DRB Application No.: 05DRB-01147 (SBP)	Project # 1004326
Project Name: LOOP INDUSTRIAL DIST. UNIT 5	
Agent: Insite Works	Phone No.: 858-0100

**CITY OF ALBUQUERQUE
PLANNING DEPARTMENT
July 20, 2005
DRB Comments**

RE: Lot 14-A—2-A, Loop Industrial District, Unit 5/spbp

**SITE PLAN**  
SCALE: 1"=20'

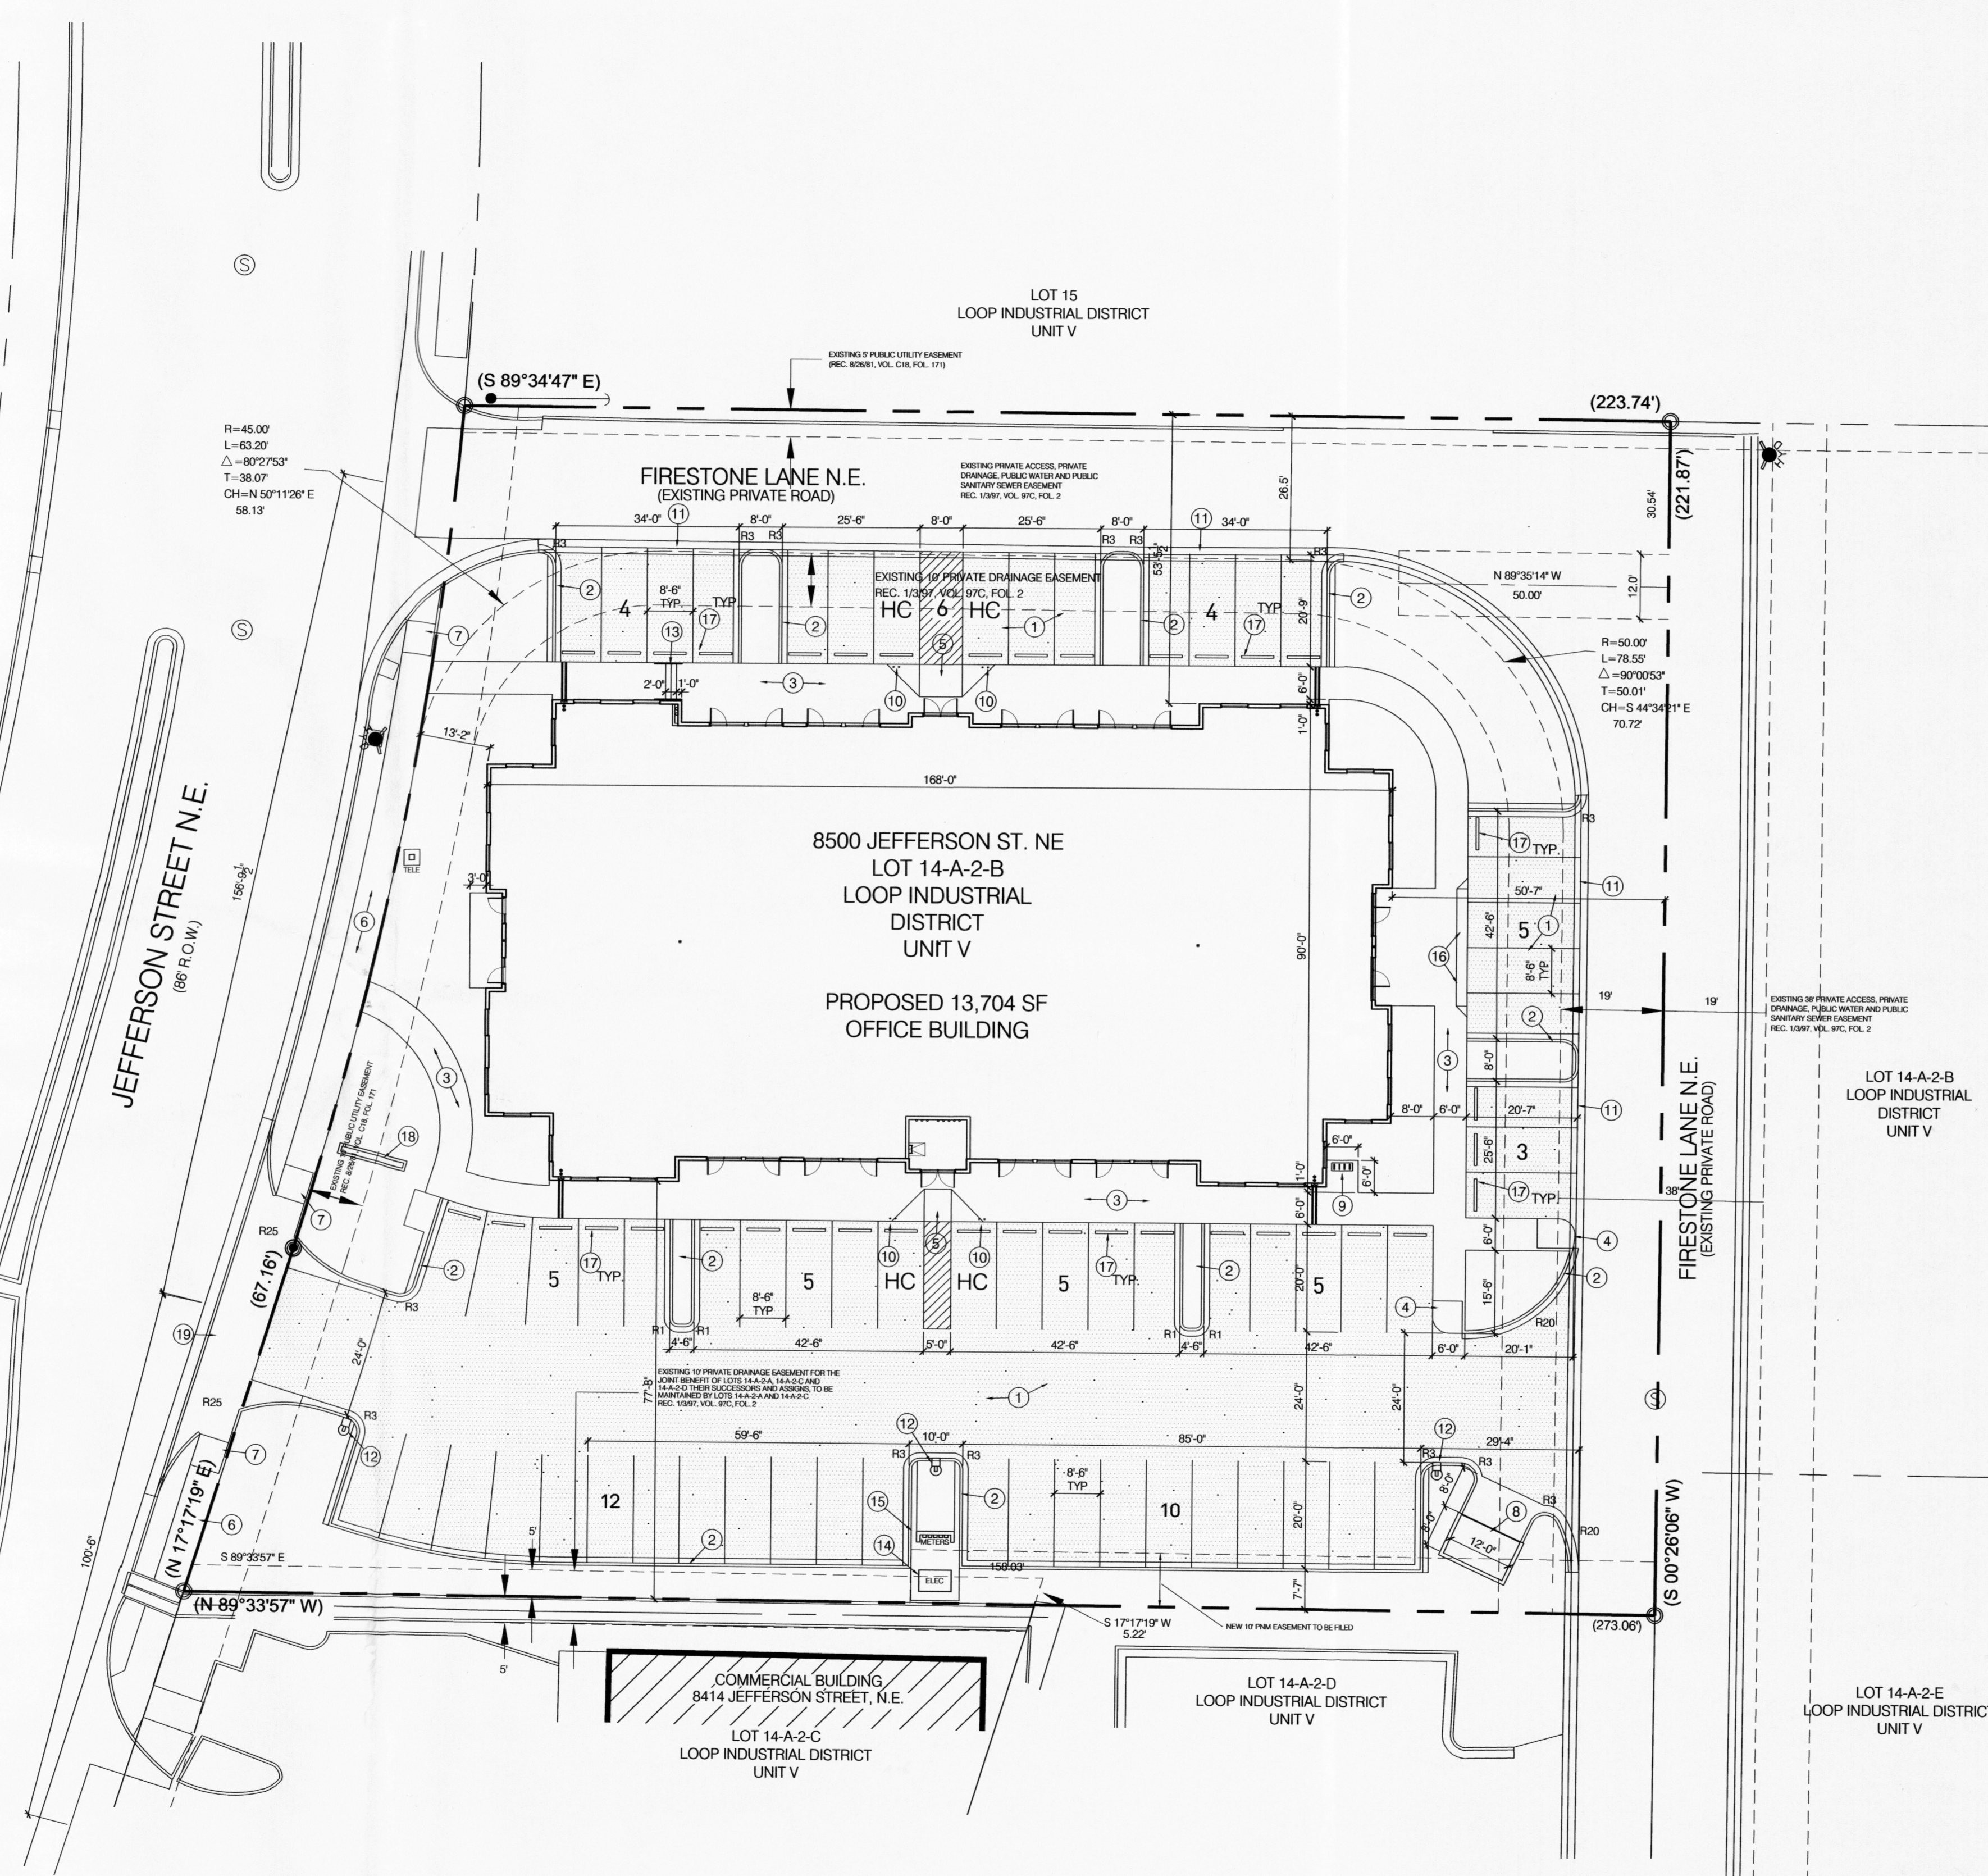
The Site Development Plan Approval Note is not needed. Please remove.

LANDSCAPE PLAN

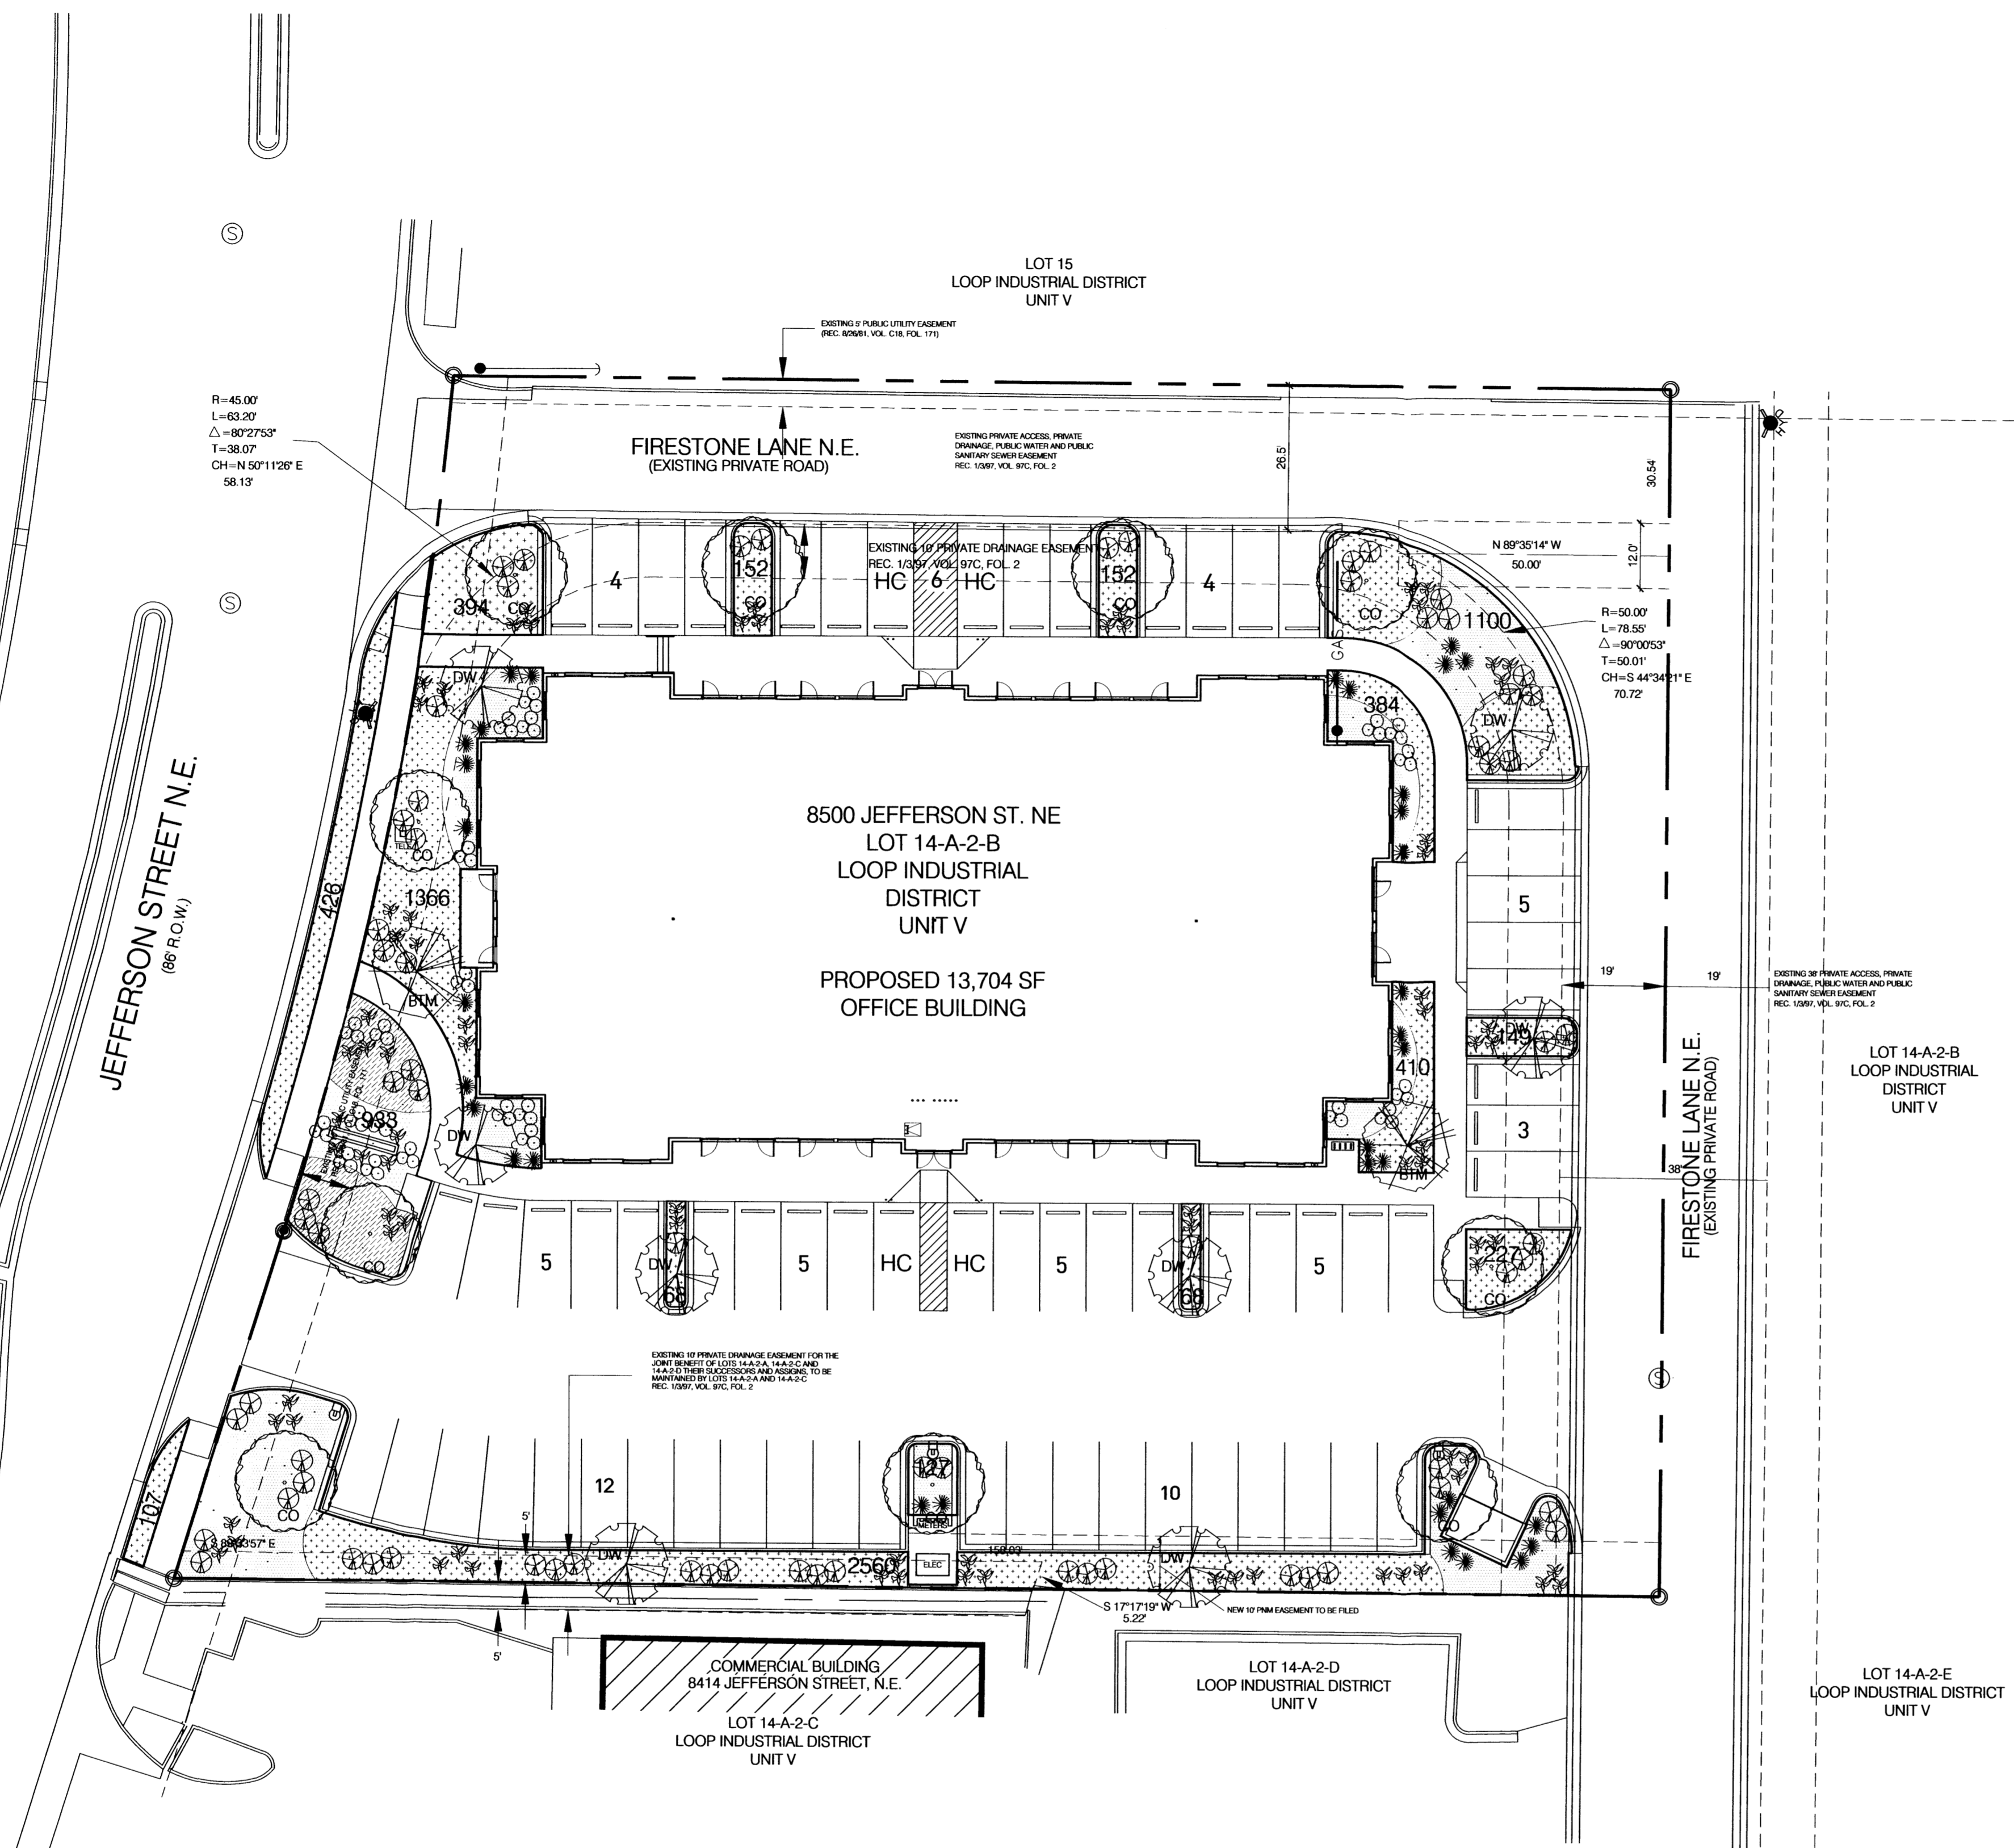
The North I25 Sector Plan requires a six foot landscaping strip on the east & north sides as well of trees, shrubs & ground cover. A design variance is needed to drop this requirement. Agent was notified on 7/18/05.

A statement of who will maintain the irrigation system is needed on the Landscape Plan sheet.

No parking space can be more than 50 feet from a tree, also a requirement of the North I25 Sector Plan.

Street trees are required every 30 feet along Jefferson. They must be 2 inch caliper at six inches above grade. Evergreen trees are not allowed. Honey locust is one lower water use deciduous that is acceptable.
